Application No: BE/59/21/PL
Site Address: 339 Chichester Road Bersted PO21 5AN
Description of works: Replacement of blockwork boundary wall with fence and new vehicular access (resubmission of BE/149/21/PL).

Thank you for your internet representation made on 23rd May 2021 which has been recorded as an objection with the comments as follows:

SITE PLAN - SHOWING VISIBILITY SPLAYS
1:500 SCALE (at A3)

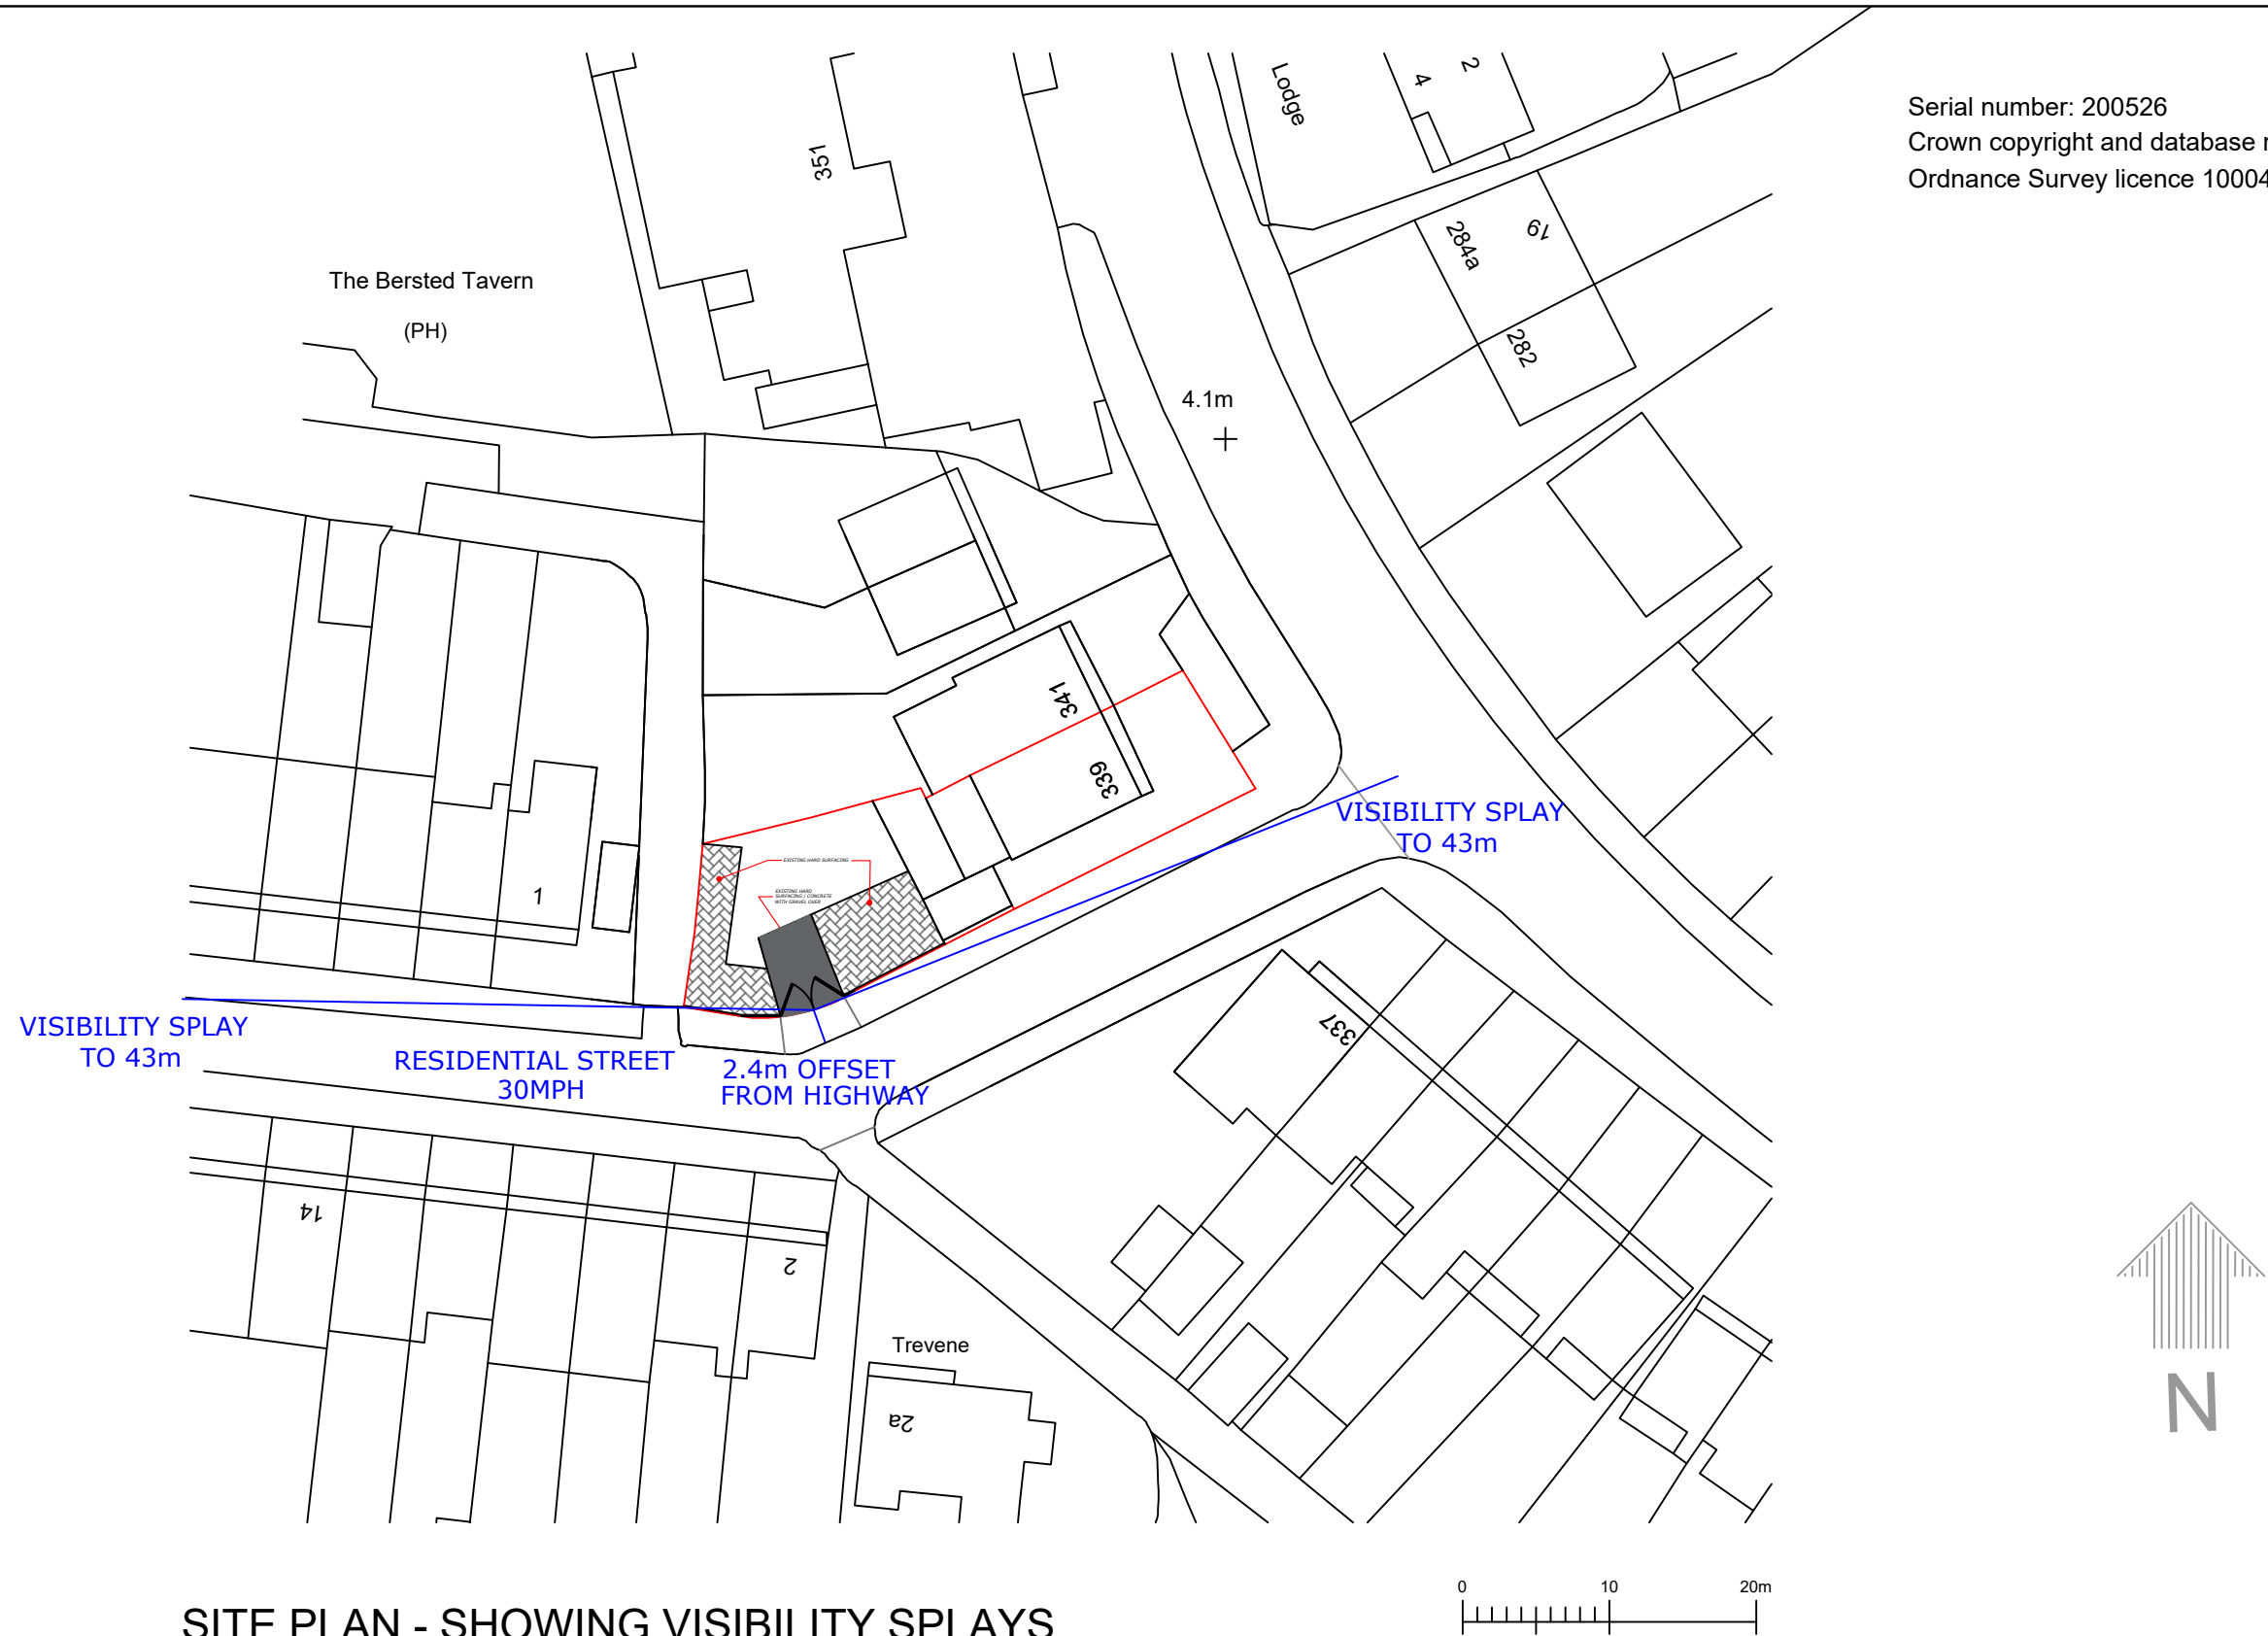
I object to the plans for a drop kerb and entrance on a bend. It is a dangerous position putting pedestrians at risk as well as a danger to traffic coming round the bend. The property already has ample parking at the front of the property. With very limited parking in Bedford Avenue already this drop kerb reduces parking for others when they already have plenty of parking on that property.
